# The Children's Hospital at Westmead Paediatric Services Building

## Architectural Design Statement - Addendum

State Significant Design Application No. SSD-10349252

Document Number: CHW-AR-DG-PSB-SSD081  
September 2021

Sheet Name		16/11/20	
SITE PLAN - DEMOLITION		Revision	
Scale		1 : 1000@A1	
Drawn By		Checked By	
HR		AF	
Project No		19038	
Drawing No		CHW-AR-DG-PSB-SSD004

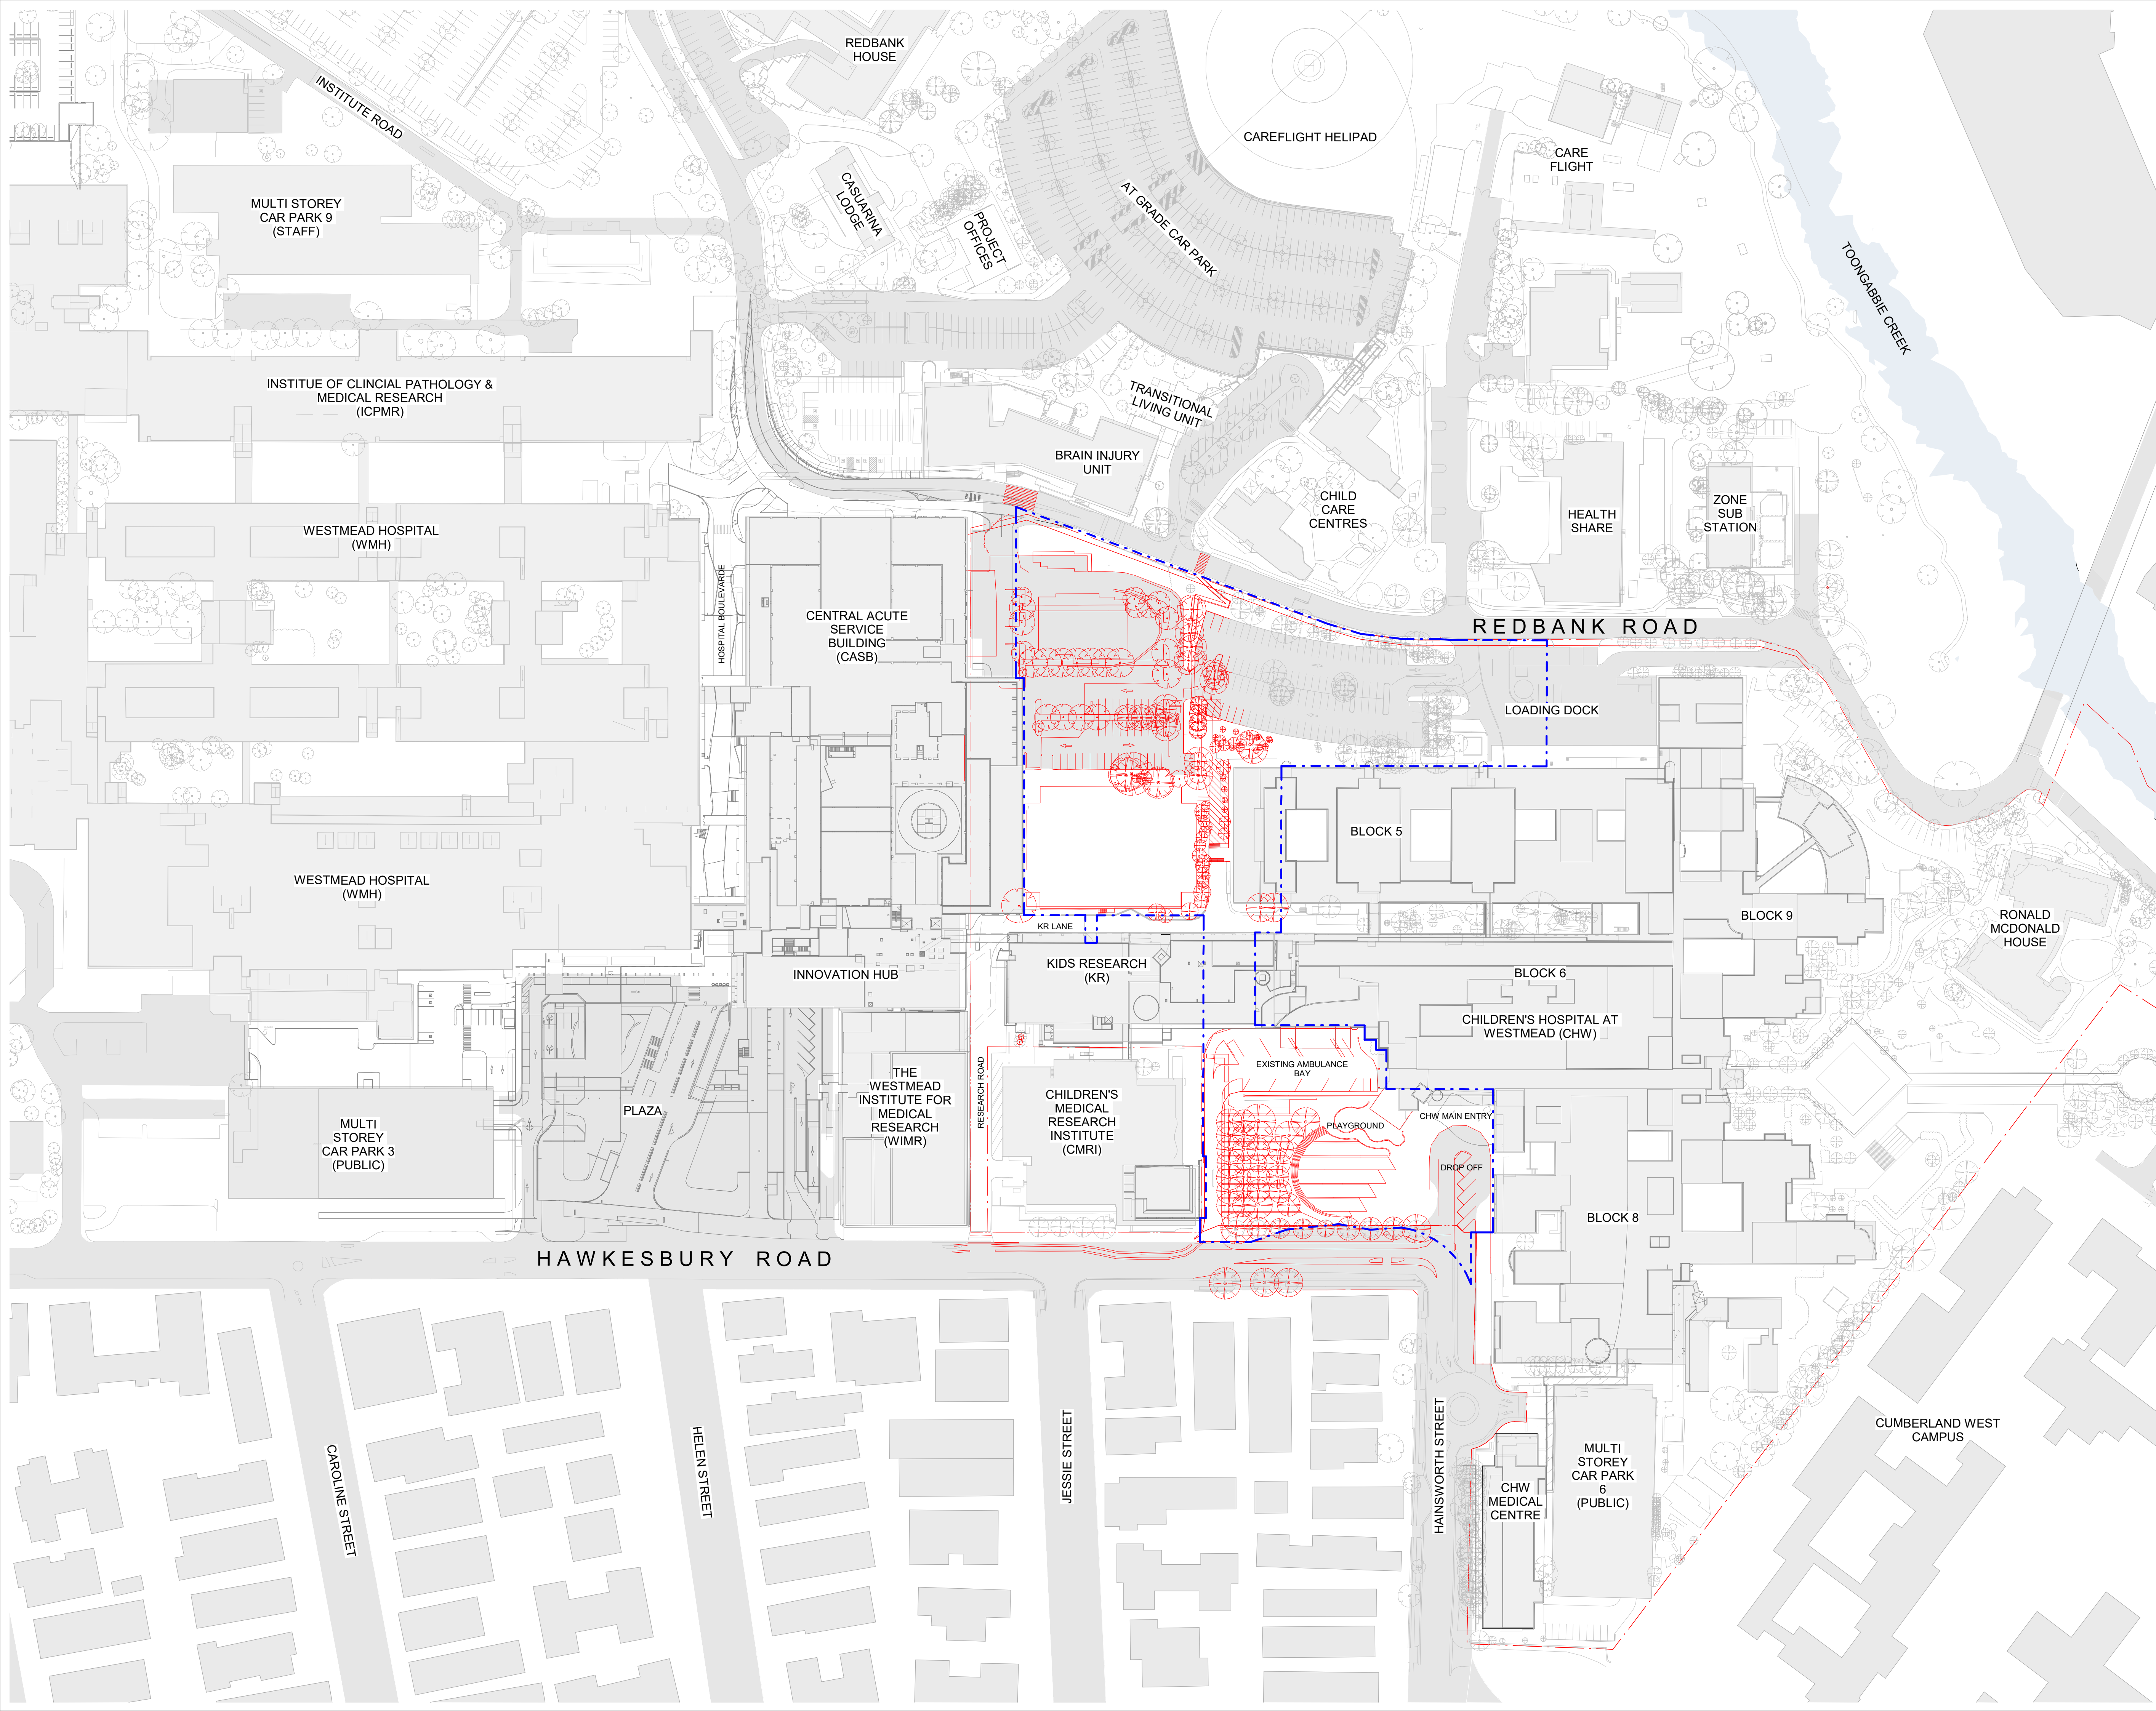
| Submission Comment/ Agency   | Response   |
|--|--|
| Identify clearly on the architectural plans and within the RtS the demolition works being sought under this proposal.  | <p>Please refer to the Demolition Site Plan – CHW-AR-DG-PSB-SSD004 for scope of demolition. The colour of items that are proposed to be demolished has been changed to improve readability and to distinguish from the red colour of the site boundary. Trees in the Forecourt area that remain, are shown in black.</p> <p>Key items proposed to be demolished:</p> <ul style="list-style-type: none"> <li>• Existing carpark where the new PSB building will be located</li> <li>• On grade parking to the north towards Redbank Road.</li> <li>• Vegetation as identified on the demolition plan</li> <li>• Existing Ambulance Bay and Playground to at the southern side of the site, adjacent to the existing drop of, on Hawkesbury Road.</li> </ul> |
